TONY MASSINGHAM

WRITTEN REPRESENTATION

HIGHWAYS ENGLAND'S RESPONSE

Drawing file: TR010019 / TR010019-003897-Works Plans Sheet 24.pdf

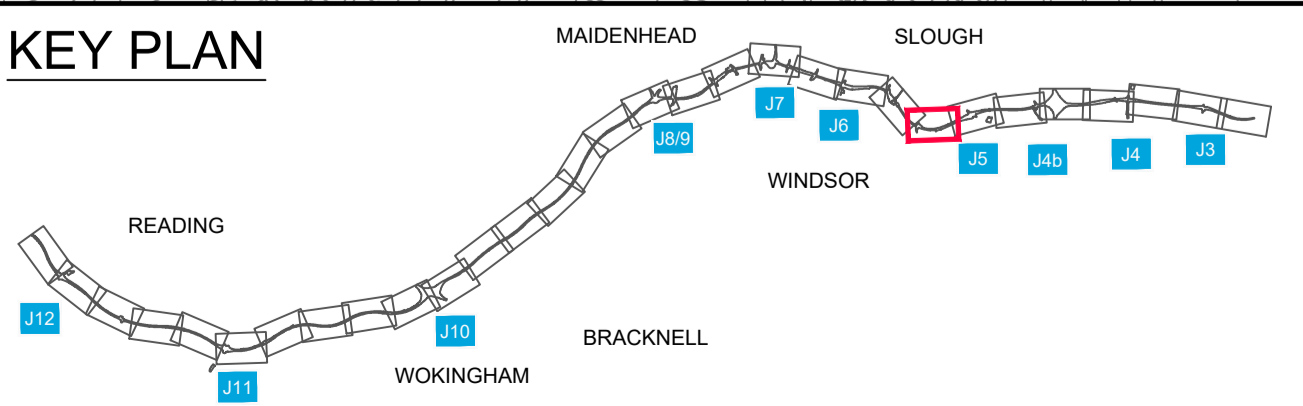
7. *Mr Massingham refers to the landing path of Heathrow's 3rd runway, which passes directly over the M4 where the footbridge needs to be extended over the B470.*

9. *Mr Massingham suggests that the centreline of the landing path to the 3rd runway passes over the M4 / B470 footbridge.*

- 7.1 Highways England confirms that there are no proposals to extend the footbridge that passes over the M4 and B470. Details of the other works in the area of the footbridge are shown on work plan sheet 24 of drawing TR010019-2.3.

- 9.1 Highways England confirms that there are no proposals to extend the footbridge that passes over the M4 and B470. Details of the other works in the area of the footbridge are shown on work plan sheet 24 of drawing TR010019-2.3.
10. *Mr Massingham suggests that the Piccadilly Line could be extended under the M25 at ground level, skirting the bottom of the Queen Mother Reservoir. Similarly, Network Rail lines could be moved to the western skirt of the Queen Mother Reservoir at the M4/B470 footbridge. He also describes a plan whereby National Express coaches from the west pass through tolls and go around Junction 5 to go through the tolls to the platform. Mr Massingham suggests that if a link is created to Windsor as a shuttle, the level crossing will become obsolete.*
